**RE: Land at Occupation Road, off Birkby Road, Birkby, Huddersfield
(Application reference 2024/90461).**

We are the owners of number 5 Birchroyd Close for which planning has been approved for a new build large detached house but due to the challenging economic climate, we have not yet started the new build. However, we will be starting to build soon. We have been notified that a large detached house has been proposed at the rear of our house on Occupation Road which backs onto our rear garden.

Drawing Title
House Plans and Elevations

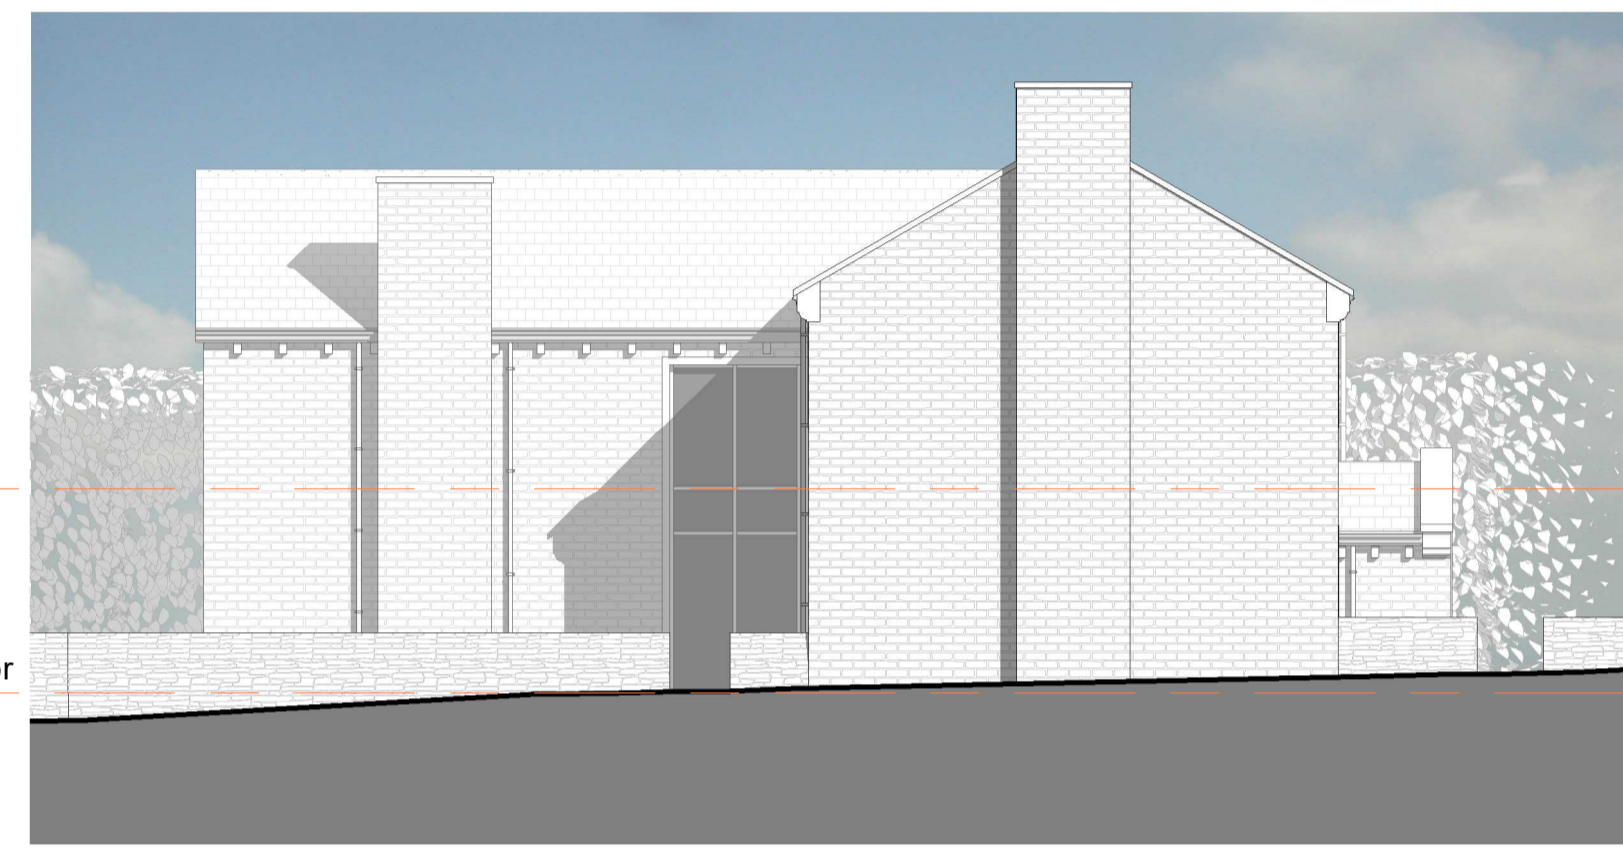
- Their double garage, driveway forecourt and the turning head facility is directly behind our existing site boundary and property.
- They will cause noise and pollution to our property.
- The double garage will also obscure our views towards the rear.
- They have not proposed any landscape between their plots and our rear boundary.
- As can be seen from the google map image, our rear hedge is showing signs of dying. When our rear hedge has died, their double garage will cause visual harm to our future new build.

- The turning head appeared to be too far into the site and appeared as if to be serving another plot in future.
- The turning head will also cause visual harm should our hedges die and is really unacceptable.
- Their proposal does not meet with some key Kirklees local plan policies and as such should be refused.
- We understand that various neighbours that the above site backs onto are also unhappy and will be providing separate objections.
